# Whalley Parish Council

## PLANNING APPLICATIONS

13 ABBOTS CROFT WHALLEY LANCASHIRE PROPOSED EXTENSIONS 1:50 MARCH 2012 PH/KH/100

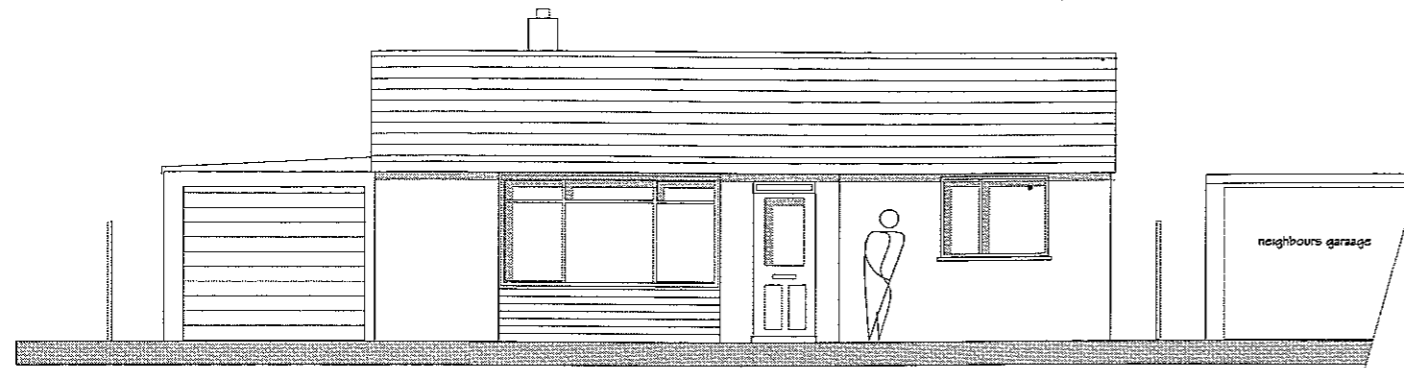
3/2012/0202	Proposal: Location:	Application to discharge condition no.4 (materials) 21 Clitheroe Road Whalley BB7 9AA
		No Observations	
tree works	3/2012/0226	Proposal:	Crown lift and crown thin three trees. Application for
9SN		Location:	Whalley Methodist Church King Street Whalley BB7
		No Observations	
	3/2012/0181	Proposal:	Two storey extension
		Location:	3 Woodlands Drive Whalley BB7 9HL
		Observation	The parish council question the extent and proportion of the proposal and the impact on the neighbouring property
	3/2012/0246	Proposal:	New extension to the front elevation to create additional bedroom space / en-suite and window to the side gable/ side extension to the rear to create a utility room.
		Location:	13 Abbots Croft Whalley BB7 9RR
		Observation	The parish council express concern that the front elevation of the property will extend beyond the existing building line.
